TO: Nelle Donaldson
Barbara Barhydt
FROM: David Margolis-Pineo Dept. of Public Services
RE: Review Comments: 11 Pomeroy Street – Single Family Home

The Department of Public Services has the following comments on the above project.

SHEET
1
REPRODUCTION OR REUSE OF THIS DOCUMENT WITHOUT THE EXPRESSED WRITTEN CONSENT OF BH2M INC. IS PROHIBITED

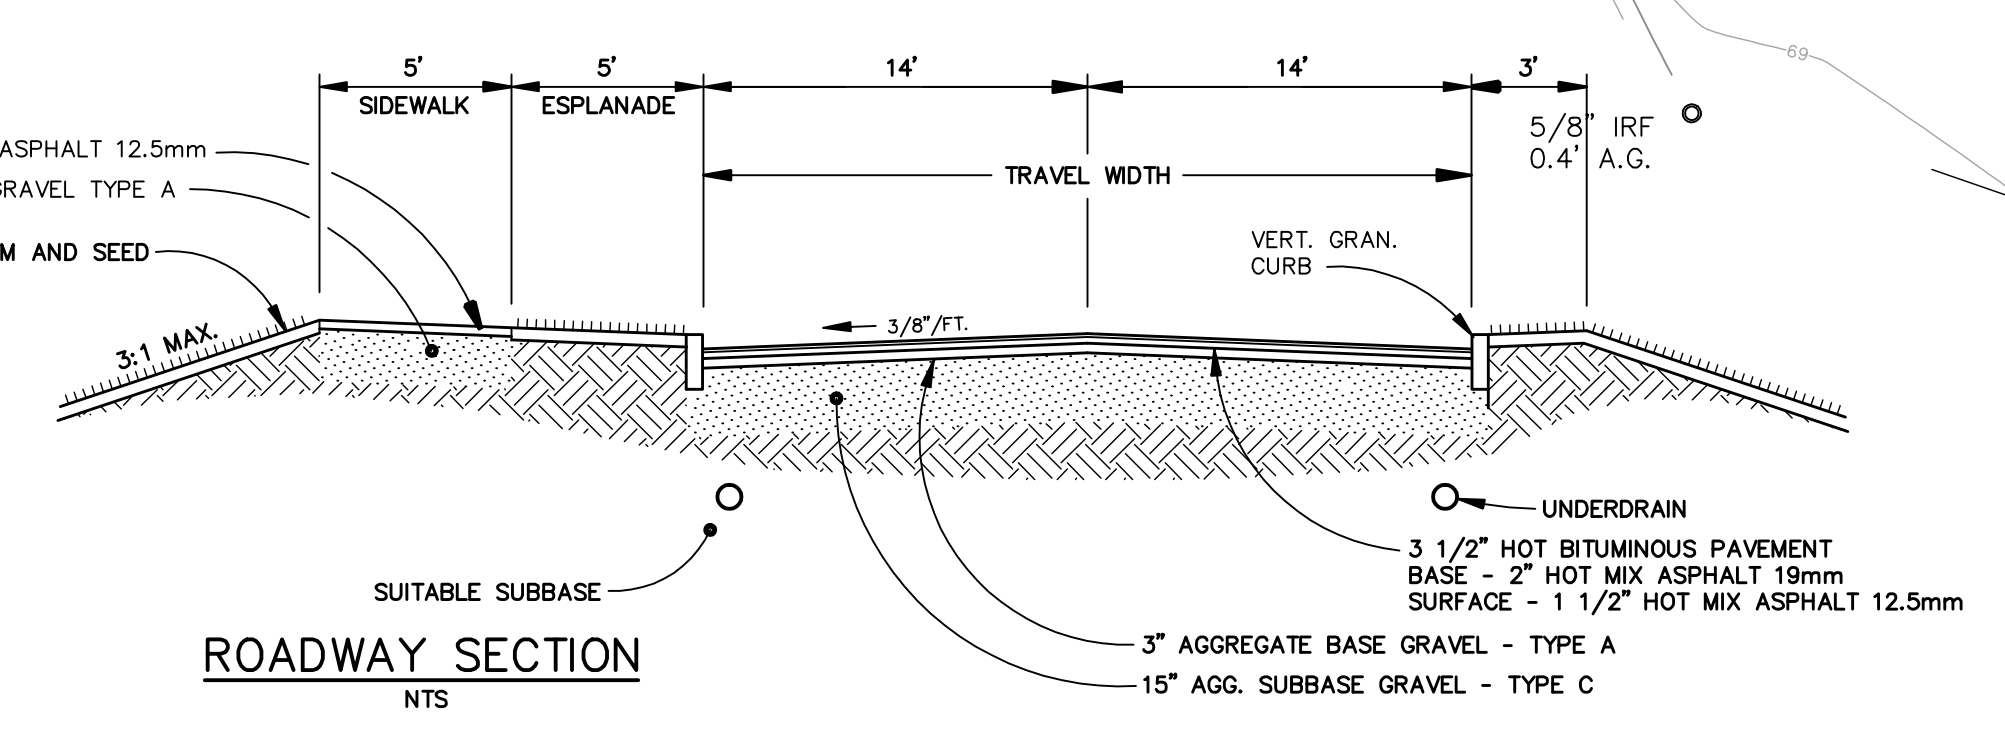
3. Please add note to plans that all work within the proposed Pomeroy Street right of way shall meet City of Portland Technical Manual standards.
Note 26 Sheet 1 now states this.

9. On Sheet 1 please indicate the status of the streets shown, i.e. accepted, vacated, paper, etc. A separate survey plan for acceptance is suggested.

Street status has not been indicated.

10. Sheet 1 needs to be on the Maine State Plane for acceptance.

11. Sanitary manhole rim are not acceptable as an official city benchmark.

The site bench mark is now on a PK in Bancroft St. What City of Portland benchmark was used to set this benchmark?

Provide information on what City of Portland benchmark was use to set elevations.

The Plan is now on a Maine State Plane.
